CVSAG deadline 5 submission

The Cliff Villages Solar Action Group (CVSAG) wishes to submit the following comments on construction traffic issues raised up to deadline 4.

HGV Routing

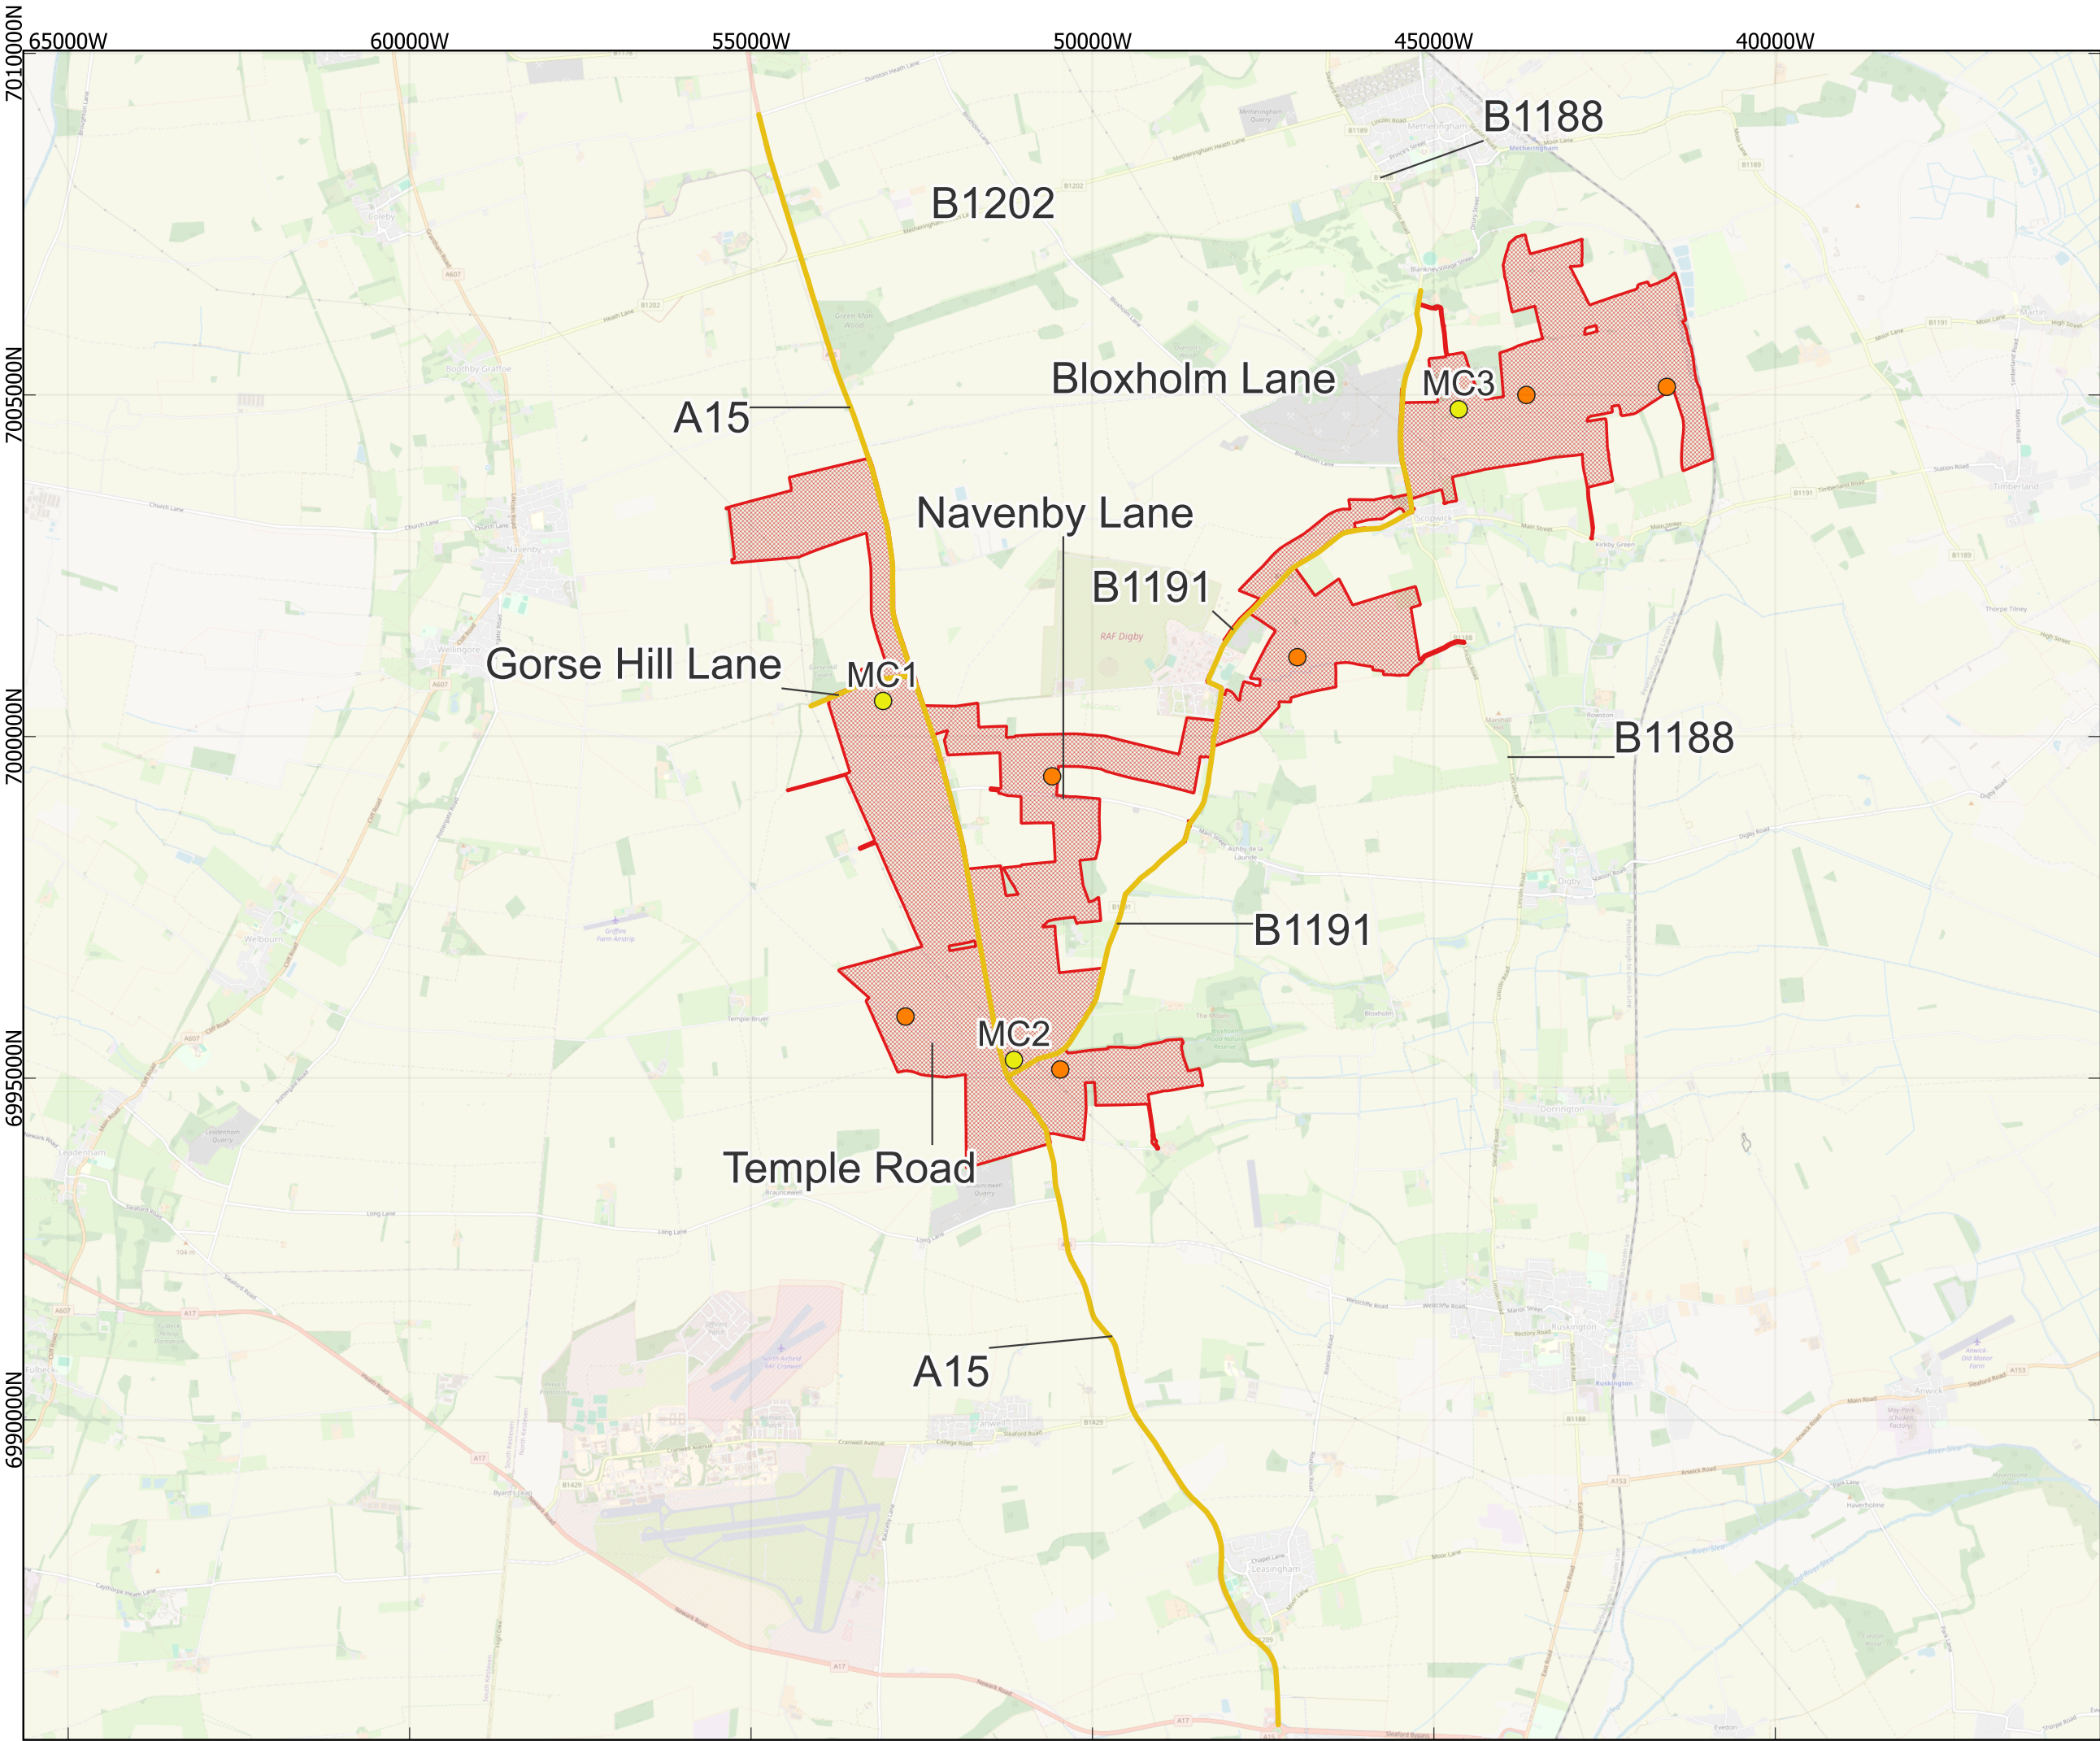
The applicant has stated that routing for HGVs, LGVs and cars will result in minimal east-west traffic through the cliff villages. Some traffic is unavoidable (e.g. for workers residing in the cliff villages or the Brant area). However, we suspect many vehicles will not follow the prescribed A15 routing and use these villages, principally Navenby and Harmston, as the most direct route to get to the A46 (for Newark, Gainsborough and beyond) or to Leadenham (to access the A17 or the Grantham direction). We have not seen proposals from the applicant that will effectively monitor and enforce the routing. We therefore ask the ExA to consider a robust requirement to enforce routing (e.g. cameras linked to compounds at the entrances to Harmston, Navenby and Leadenham with tiered consequences for failing to comply).

The updated CTMP (REP4-029) has two significant amendments. Paragraph 5.6.3 now makes it clear that cars and LGVs will be subject to the B1202/A15 embargo. A new paragraph 4.1.10 says “LGV routing is available as per HGV routes”. CVSAG believes that merely to point out availability is insufficient and does not reflect our understanding that routing would also apply to LGVs and cars. The ExA is asked to consider including a requirement to control construction transit by cars and LGVs – for example, replacement of the first sentence of 4.1.10 by “Cars and LGVs will also adhere to the routing for all trips involving transit to or from the A17 and A46”. Even with the embargo, such a requirement is appropriate to prevent vehicles using unsuitable minor roads. However, without mandatory routing during the embargo period, it is likely that many cars and LGVs will transit through the cliff villages to avoid the embargo, displacing congestion rather than reducing it. The title of appendix 2 should also be amended to reflect the inclusion of cars.
